Engineers Comments Regarding Surface Water Drainage

Application Reference:	WA/106/24/DOC	Reviewer Reference:	ADC/EXT2/D2134/68
Planning Officer:	Kathryn Welch	Date of Review:	24.02.2025
Site Name:	Land East of Tye Lane Walberton		
Application Description:	Approval of details reserved by condition imposed under reference WA/124/23/S73 relating to condition number 23(b) - SuDS System, and condition number 25(b) - SuDS Maintenance Manual.		
Assessment Number:	1 of 2

As Constructed Survey

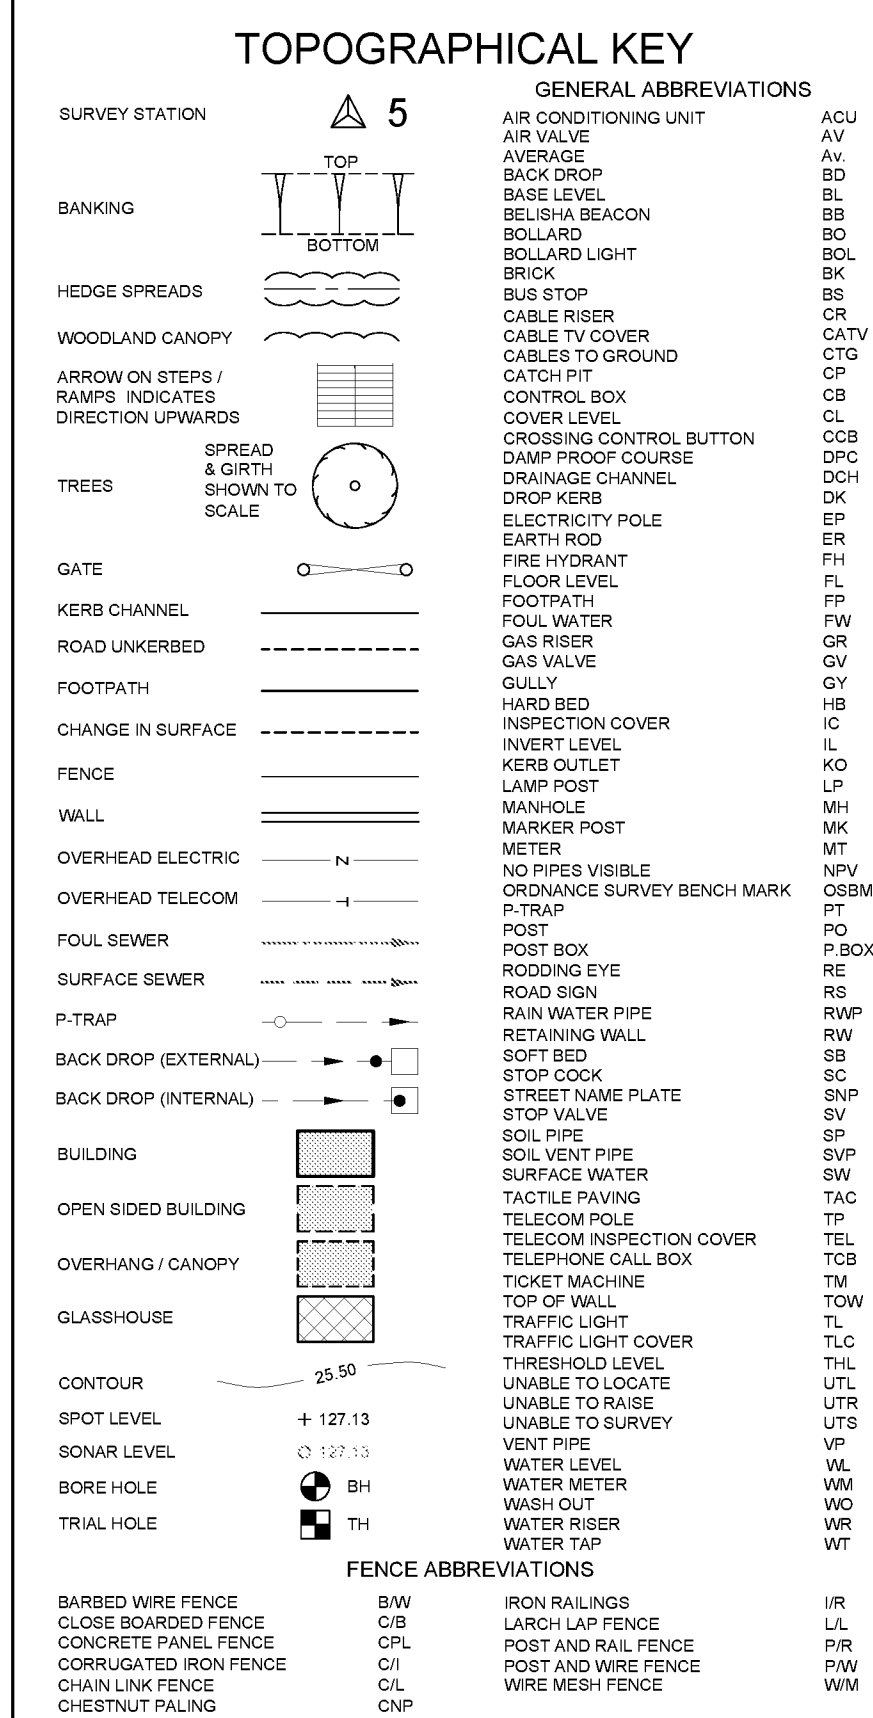
8.	The report should include an As Built survey to the requirements listed in ADC verification guidance note. It is recommended that the author reviews this list and arranges the revised report accordingly.	Appendix D provides an as-built topographical survey however this only captures the swales and basins for phase 1. Comprehensive evidence for phase 2 is required. Evidence must be provided to ascertain if the FFL's for plots, roads and how they compare to the SUDS permeable pavement and to ensure no increase in flood risk.
